RESPONSE TO SUBMISSIONS REPORT

MAJOR PROJECT APPLICATION NO. 08_0194

**KINGS FOREST STAGE 1
SUBDIVISION AND BULK EARTHWORKS**

MAY 2012

DRAWING NUMBER		AMEND.
12301-A11-044		B

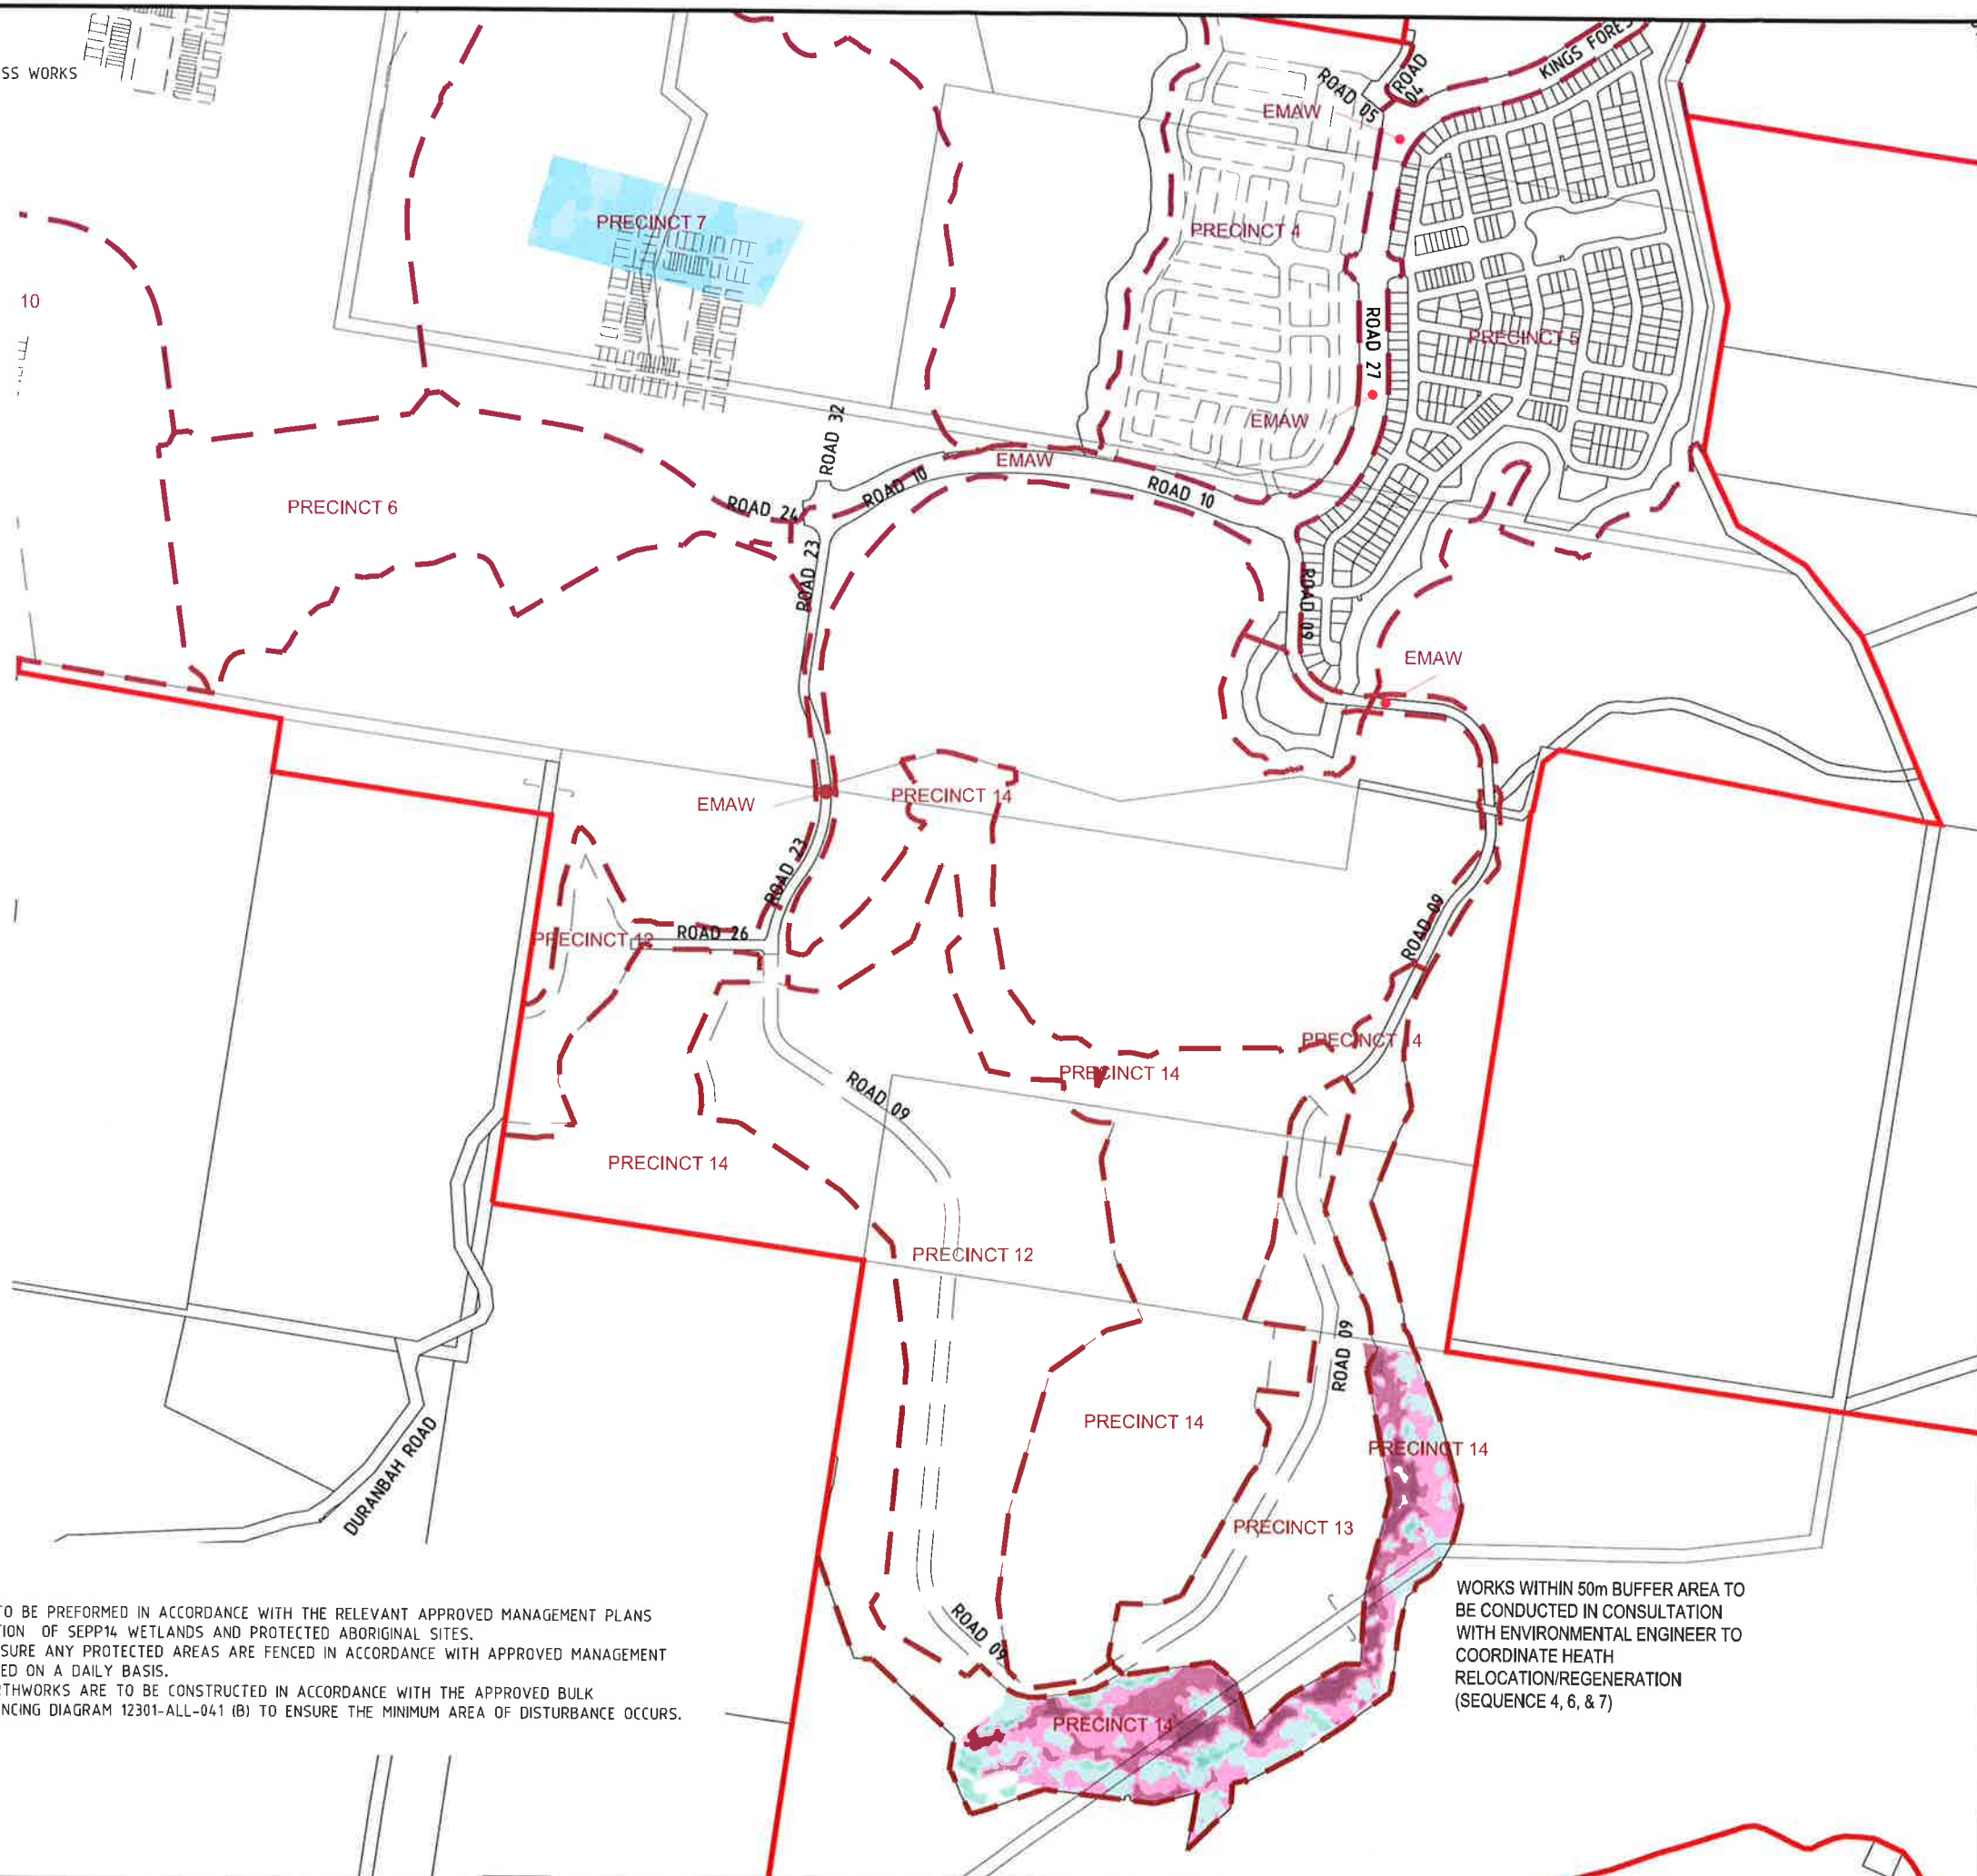
64		The department requires further detailed plans showing the sequence of earthworks and maximum exposed areas	Detailed plans will be provided with the PPR.
65		Plans submitted for earthworks in Precinct 4 are not sufficiently detailed for Project level approval	Clarify with DOPI what further detail is required. Detail will accompany the Construction Certificate Application.
66		Further details are required of the proposed recipient location of fill from Precinct 5 (and Precinct 4 if further details are provided) to enable movement of fill from Precinct 5	See response to Item 64 .
67		Further discussion is required on how the bulk earthworks across the rest of the site is intended to be undertaken	See response to Item 64 .
68		AS 3798-2007 Guidelines for earthworks for commercial and residential development should be referenced	Plans and reports will be amended to refer to AS3798-2007.
69			
70		00. DoP / Eco Logical Australia Pty Ltd (ELA)
